***MODIFICATION REQUEST:  
Mixed Use Development, 330 Church  
Street, Parramatta  
MP 10\_0171 MOD 3***

Director-General's  
Environmental Assessment Report  
Section 75W of the  
*Environmental Planning and Assessment Act 1979*

November 2013

PROJECT: RIVERFRONT APARTMENTS  
330 CHURCH STREET  
PARRAMATTA NSW  
DRAWING NAME: Plan\_Parking Level 03

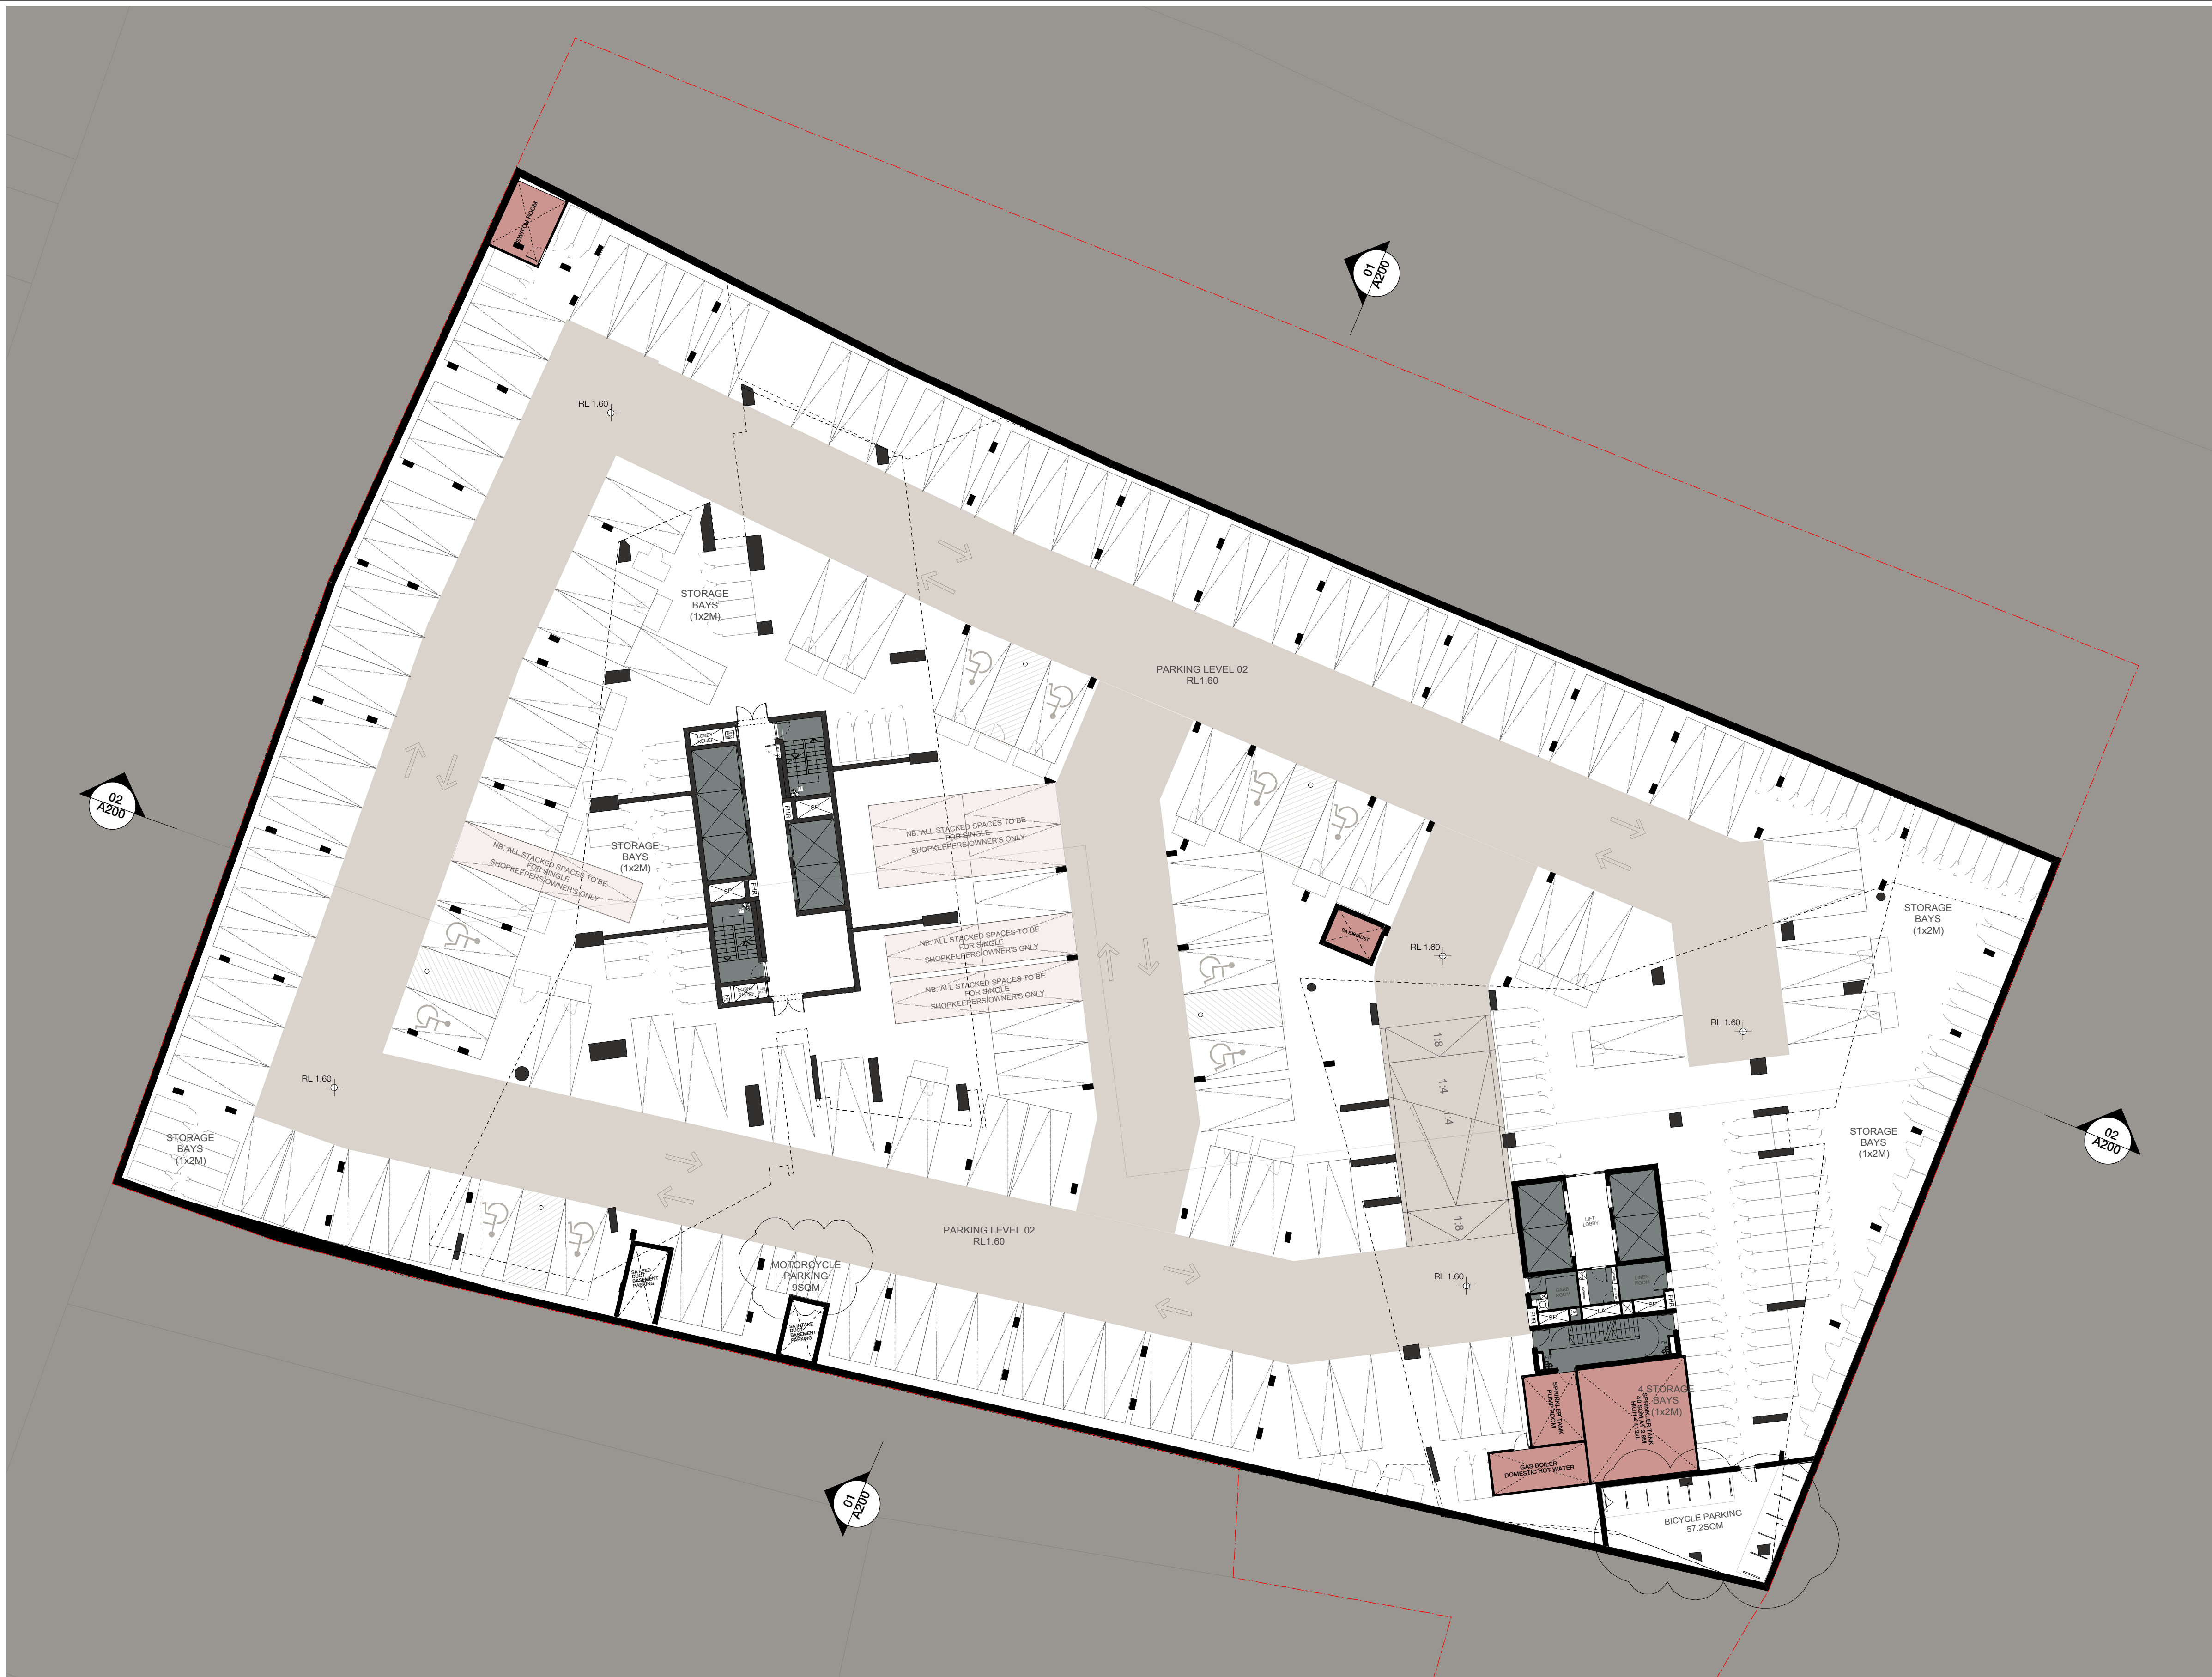
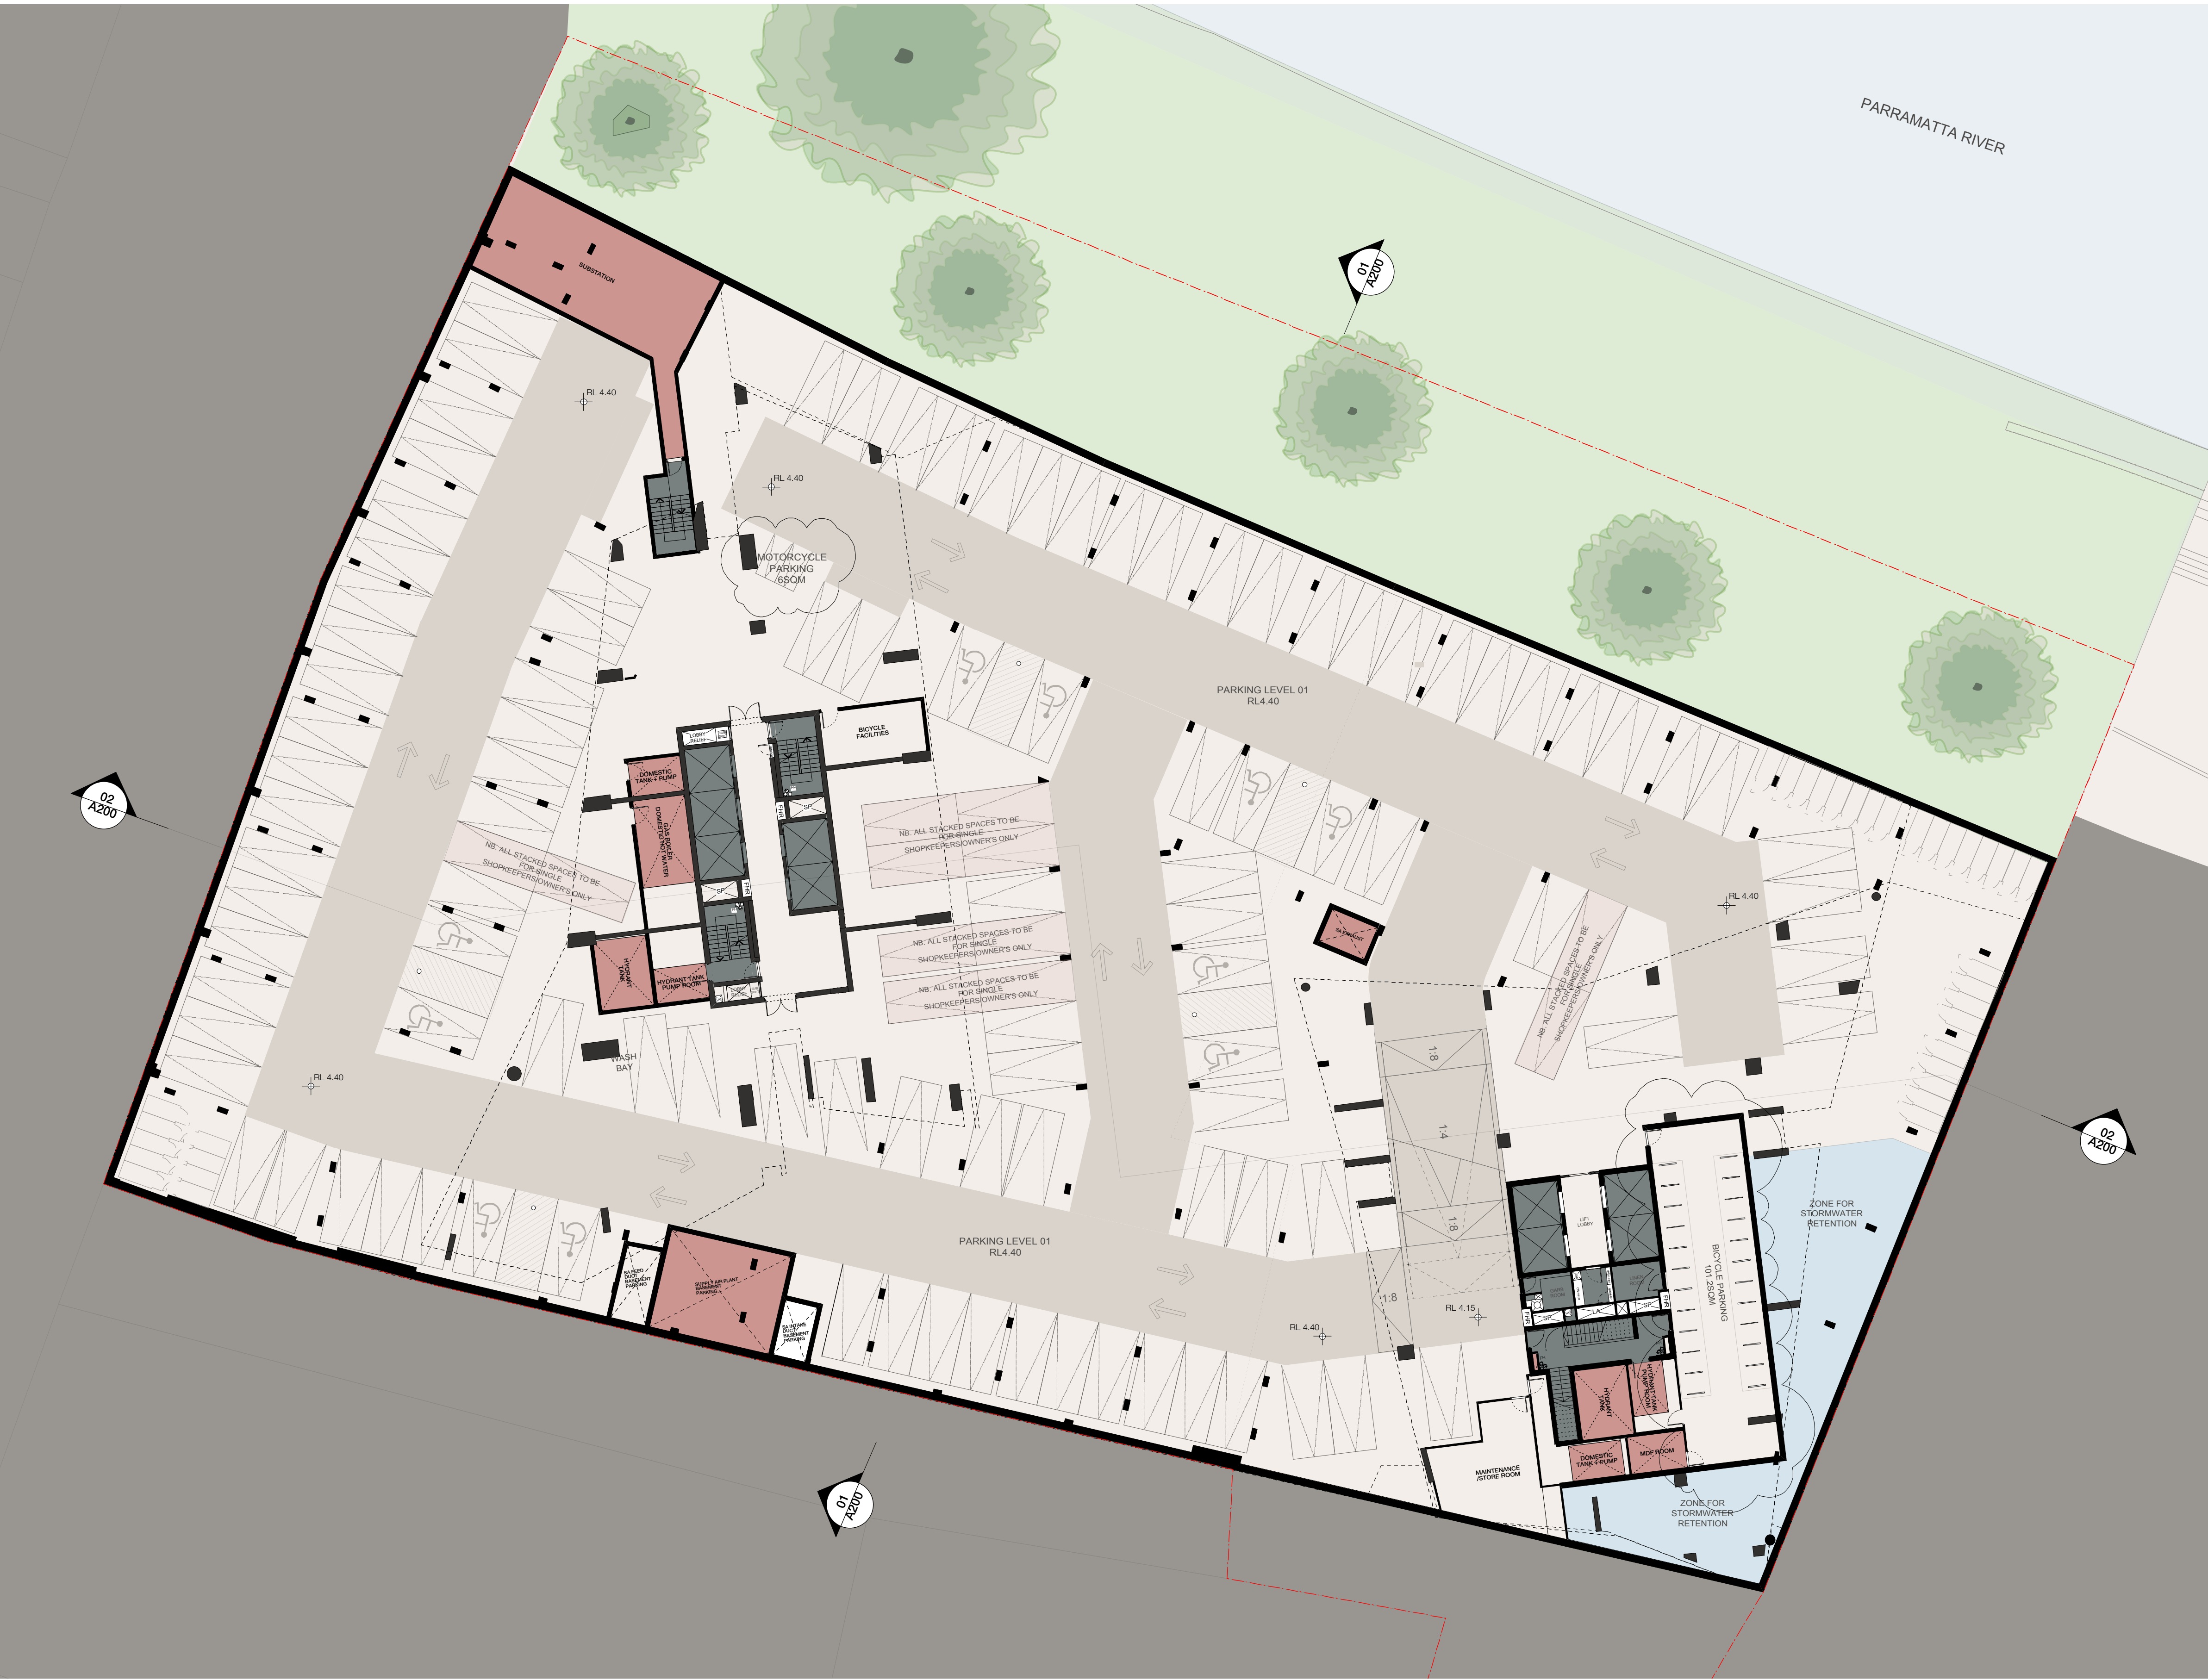
- Two parking spaces on each podium level do not comply with the reversing swept path requirements of AS 2890.1, AS 2890.2 and AS 2890.6;
- The sight lines for motorists exiting the basement do not comply with AS 2890.1;
- Impacts on the loading, parking and pedestrian access arrangements at 328 Church Street;
- Amended plans should be provided to depict how the driveway that will run through the future public square will be designed to ensure vehicle and pedestrian conflicts are mitigated; and
- Amended plans should be provided to identify the location of security gates and security card readers.
